Subject: Rezoning Petition Review

Date of Review: April 28, 2022 (**Revised August 17, 2022**)

Rezoning Petition #: 21-256

Location of Property: Approximately 150.78 acres located on the north side of Old Concord Rd, east of N Tryon St and south of W Rocky River Rd.

SHEET NUMBER:  
**RZ-1**

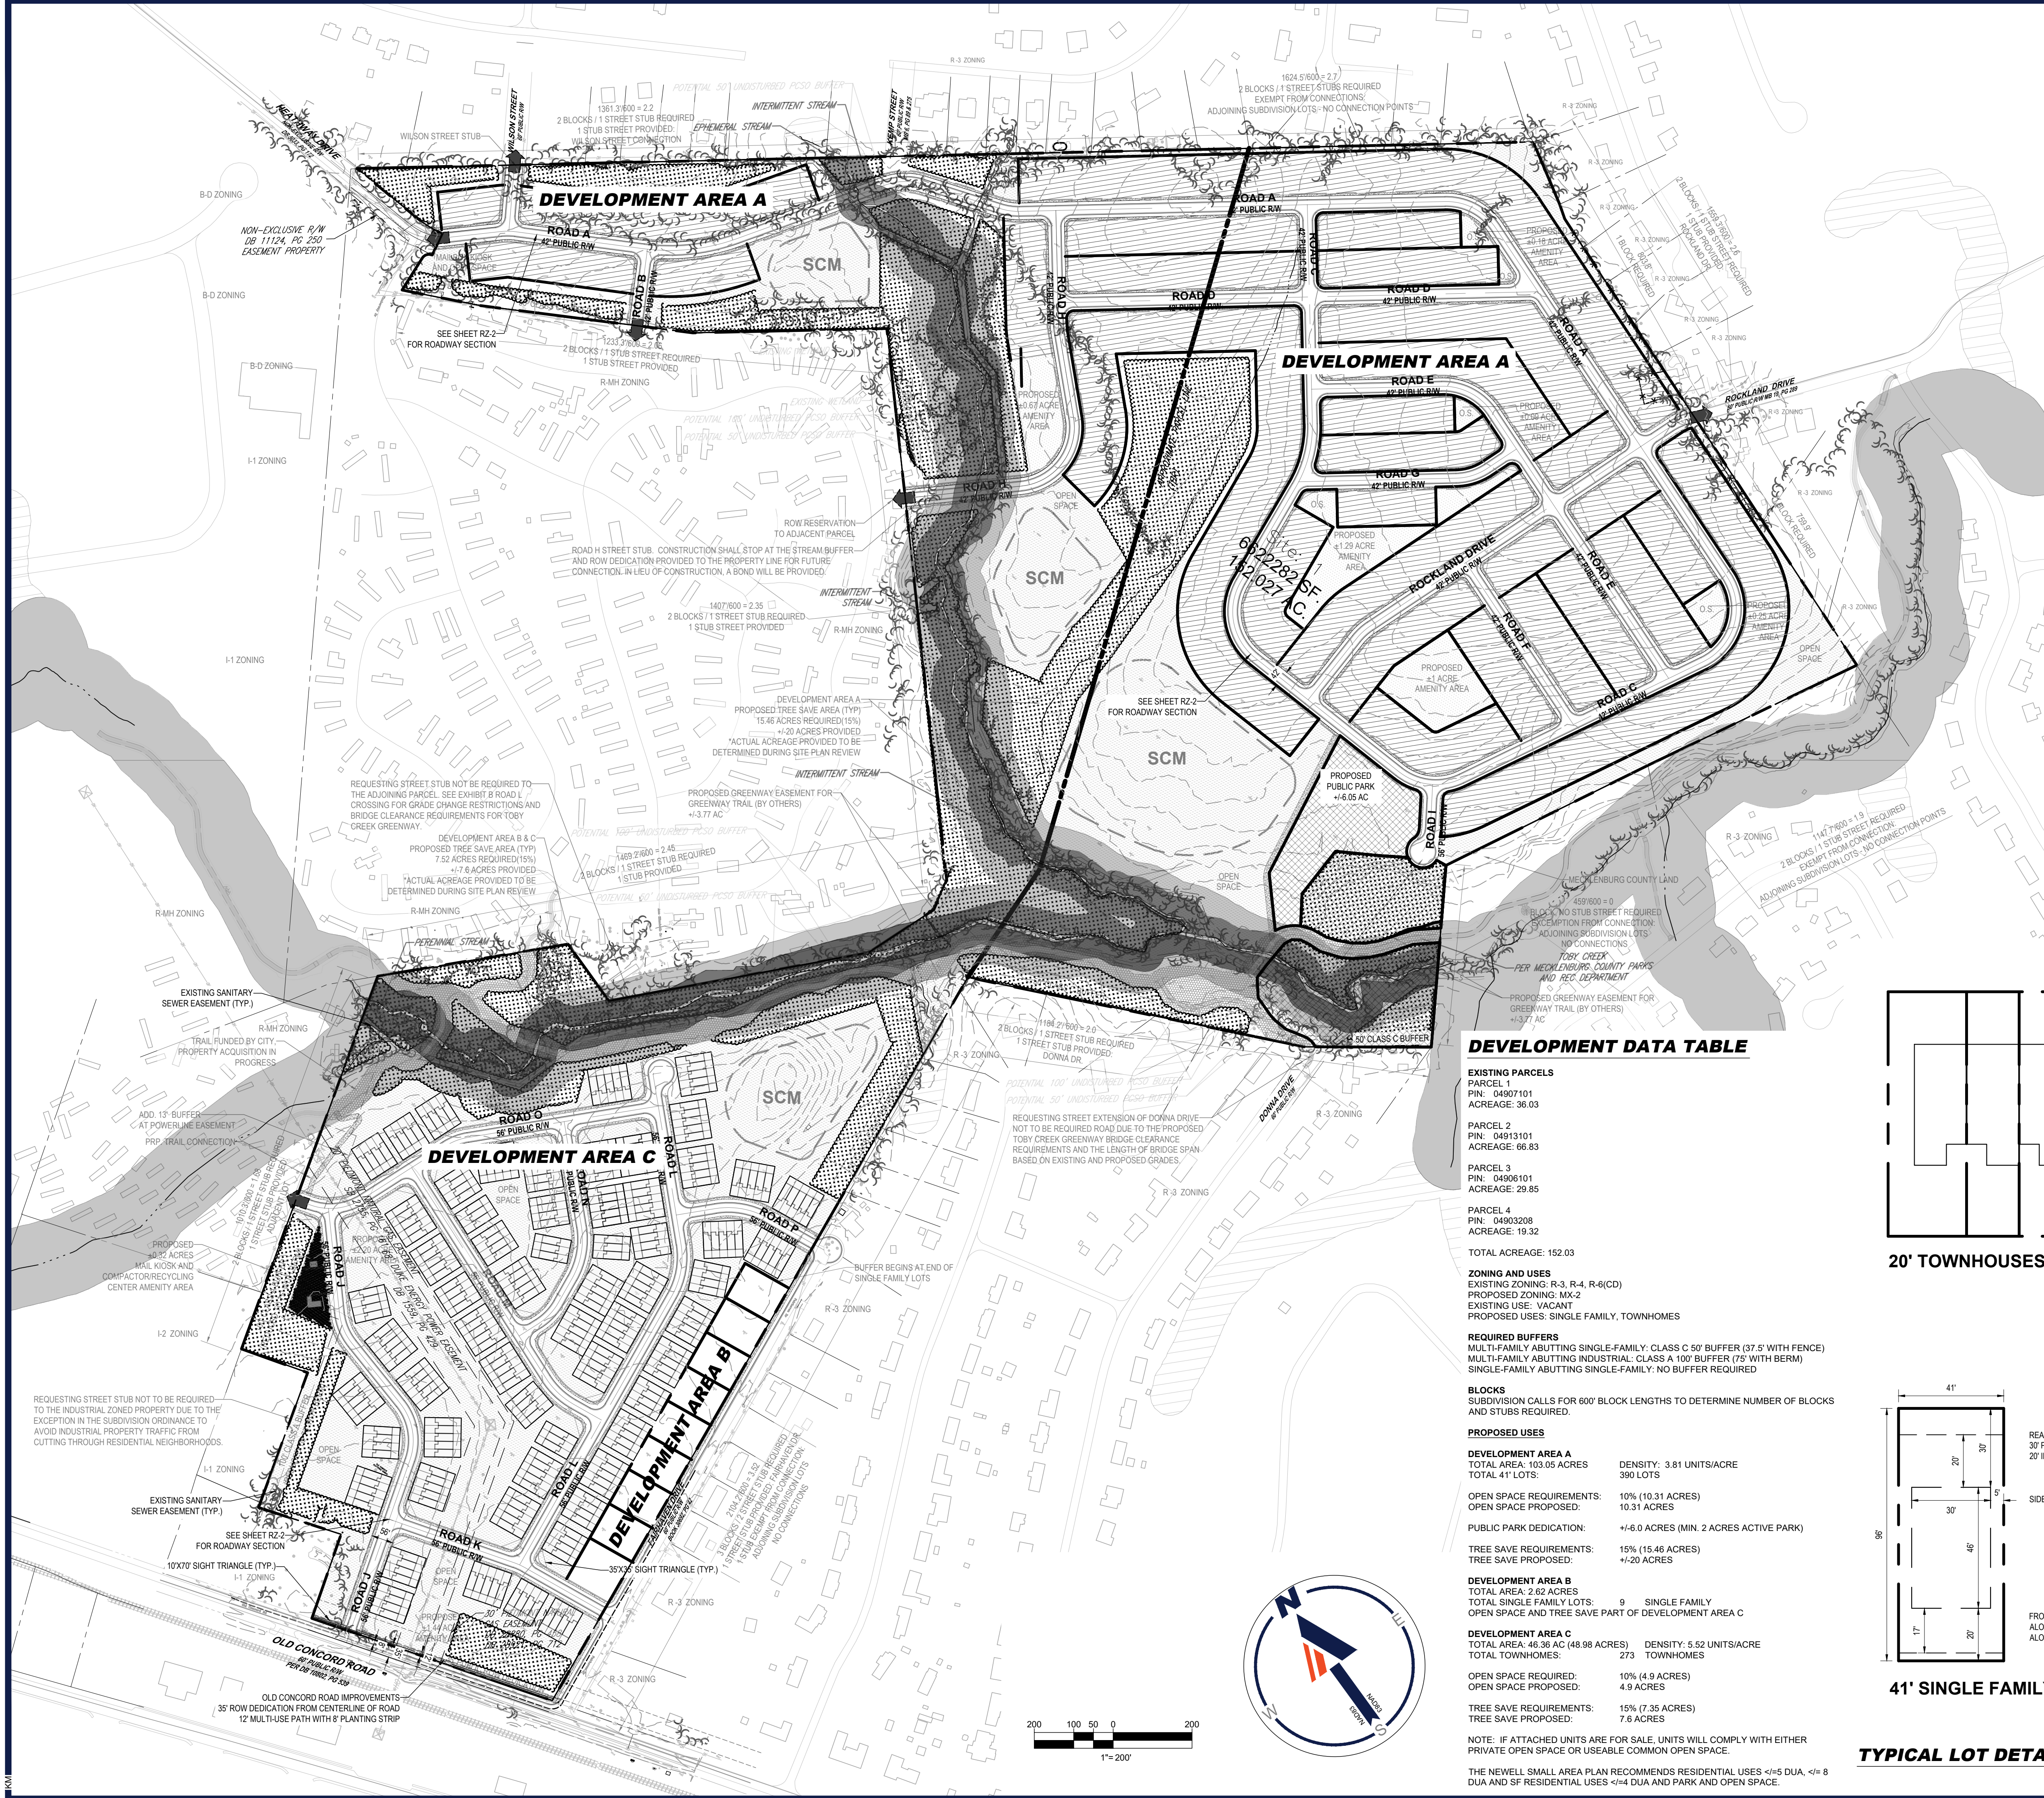
Please check and confirm PCSO Buffers on site. The site plan only shows 50-ft Buffers which should be 100-ft Undisturbed PCSO Buffers. City of Charlotte GIS also indicates a 50-ft Undisturbed PCSO Buffer approximately between the lower 2 SCMs on Development Area A.

Please show and label “*Potential 50-ft Undisturbed PCSO Buffer*” and “*Potential 100-ft Undisturbed PCSO Buffer*” on the site plan and include the following note under Environmental Features: “*Development within any SWIM/PCSO Buffer shall be coordinated with and subject to approval by Charlotte-Mecklenburg Storm Water Services and mitigated if required by City ordinance. Petitioner acknowledges intermittent/perennial stream delineation reports are subject to review and approval upon submission of development plans for permitting and are not approved with rezoning decisions.*”
